Recommendation Report for Planning Permission for Works or Extension to a Dwelling

REF NO: M/40/22/HH

LOCATION: 25 Sea Way
Middleton-on-sea
PO22 7RZ

PROPOSAL: Erection of single storey front extension to create garage/store.

Proposed Garage
at 25 Sea Way, Middleton-on-Sea, Bognor Regis
for Mr and Mrs S Donovan
Drawing P02 March 2022 Scale 1:100 & 1:500 @ A3
Planning Drawing - Roof Plan, Elevations & Block Plan

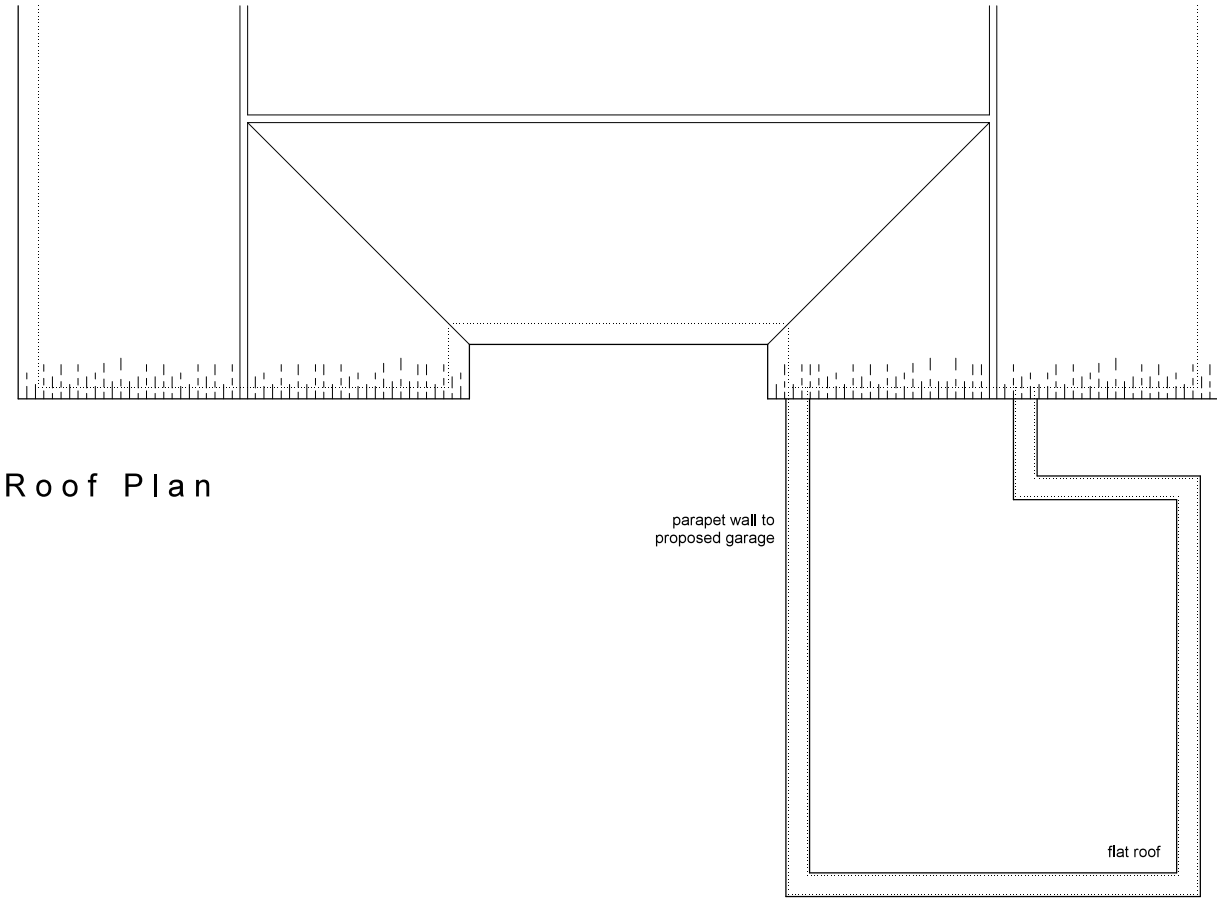
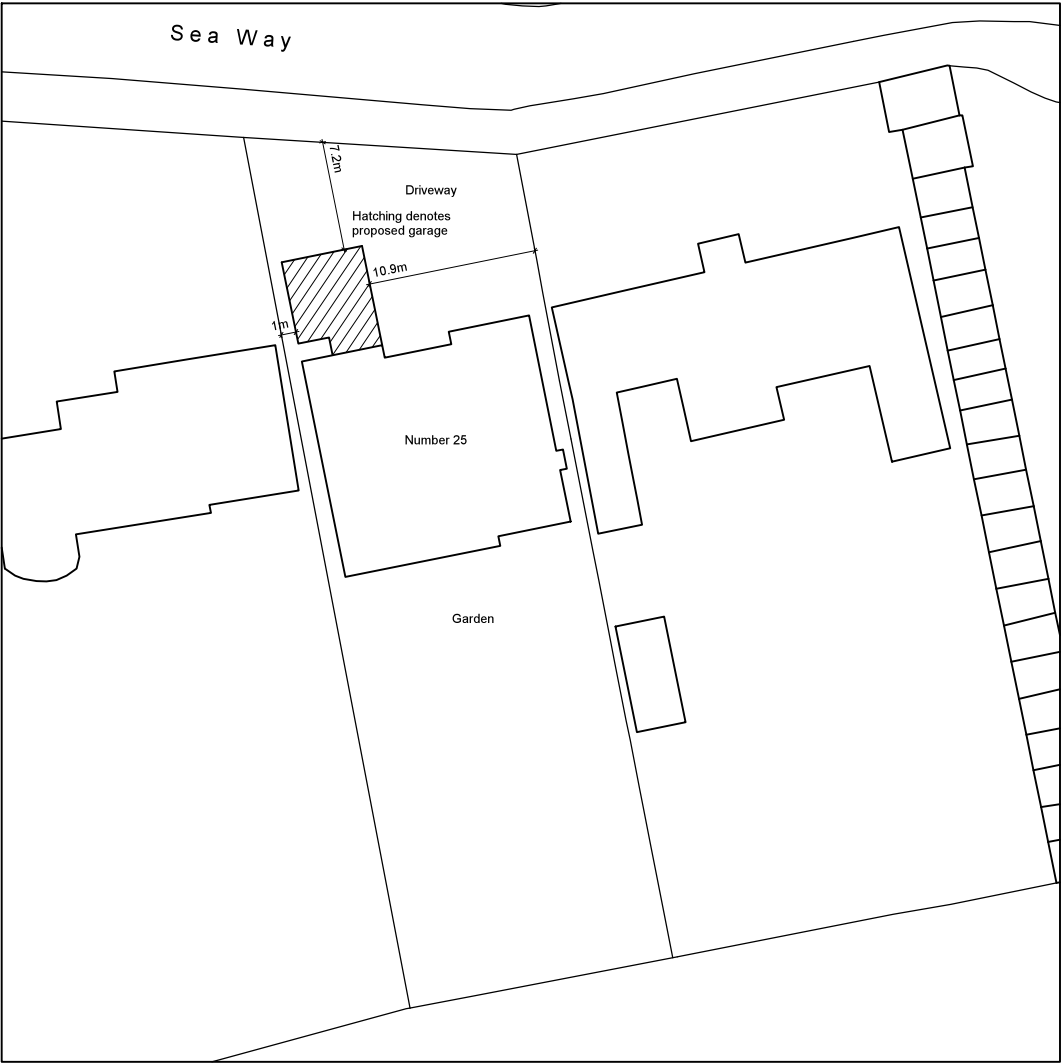
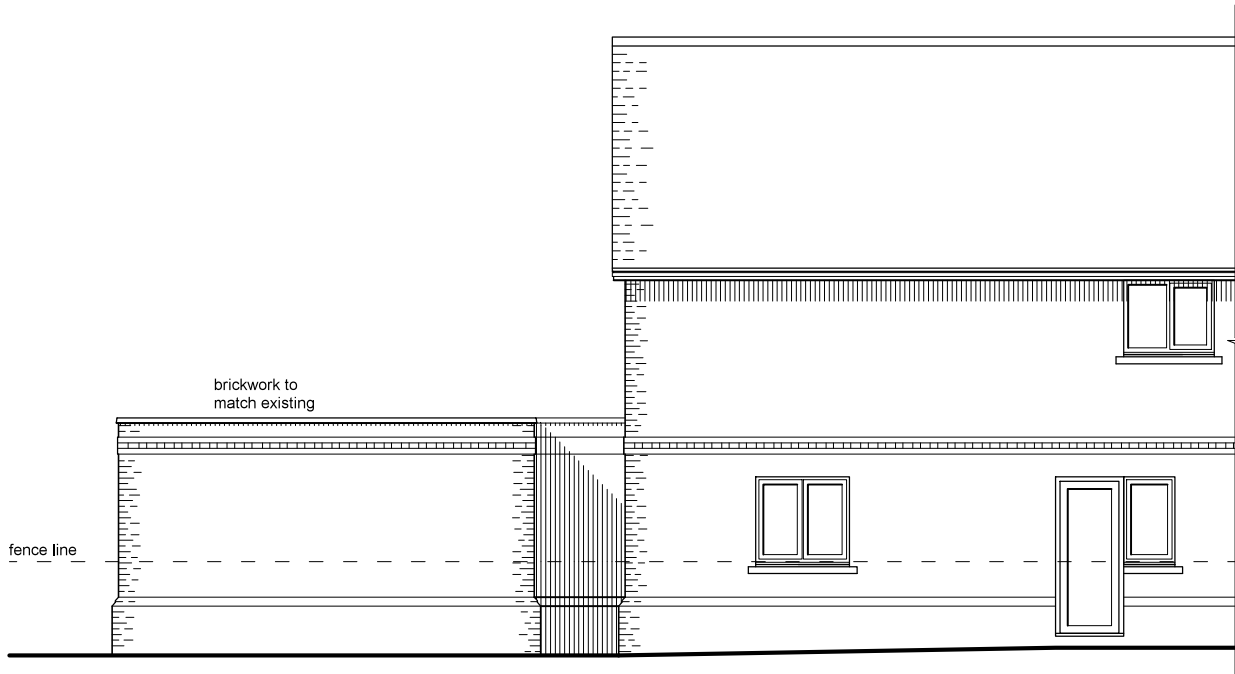
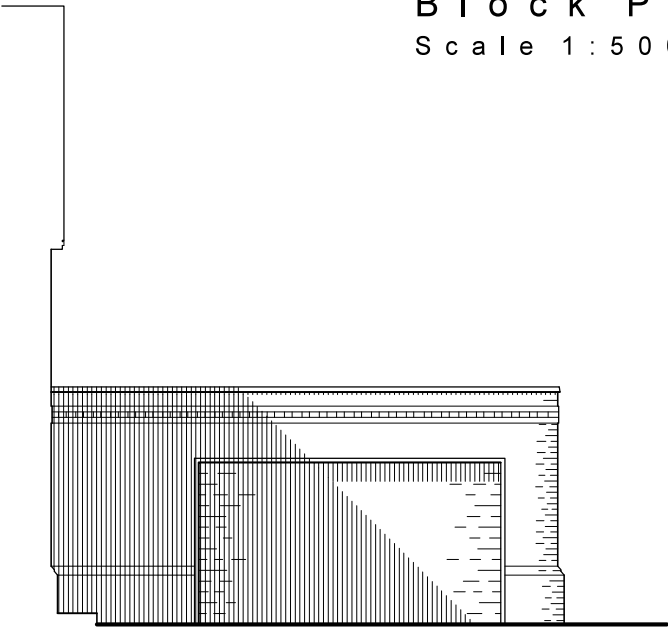
The front extension is to be approx. 5.4m in width, 6.7m in depth and 3.1m in height. The extension is to serve as a garage/storeroom and is sited to the front of the dwelling. The host property features a substantial curtilage including a large front driveway. This extension features a flat roof design and is of a scale which is visually subservient to the host dwelling and retains a substantial front driveway. Although Section M suggests front extensions should feature a pitched roof design, the flat roof design is not unacceptable in this instance given the siting and design of the proposal.

Section M of the Arun Design Guide states that front extensions should generally not project further forward than 1.5m and should not disrupt the established building line. The extension would project forward of the property and disrupt its currently even frontage however, the street features examples of forward projections, front garages and it is not a uniform building line.

Materials proposed for use on the extension are to match those on the existing dwelling. It features a

front window which matches the design of the windows on the existing front elevation, respecting existing prominent features on the front elevation. It would not have an adverse visual impact on the street scene or the host property.

The proposal is sited to the West side of the front elevation. The dwelling to the West (No. 27 Sea Way) features a garage at its East site boundary that meets the host property. This proposal will not significantly obstruct any forward viewpoints at the front of No. 27. The scale and siting of the proposal are such that there will be no adverse impacts by way of overbearing or overshadowing on any neighbouring properties.

There is to be 1 No. new window to the front of the garage. This viewpoint will lookout to the street and have no adverse impacts by way of overlooking on any neighbouring properties.

This proposal will occupy approx. 33.5sqm of the existing driveway. Although this will reduce the available parking space, the property would retain a substantial driveway capable of occupying more than 3 No. cars. This is appropriate and compliant as the parking standards guidance document identifies this area as parking zone 2 and requires a maximum of 3 No. parking spaces.
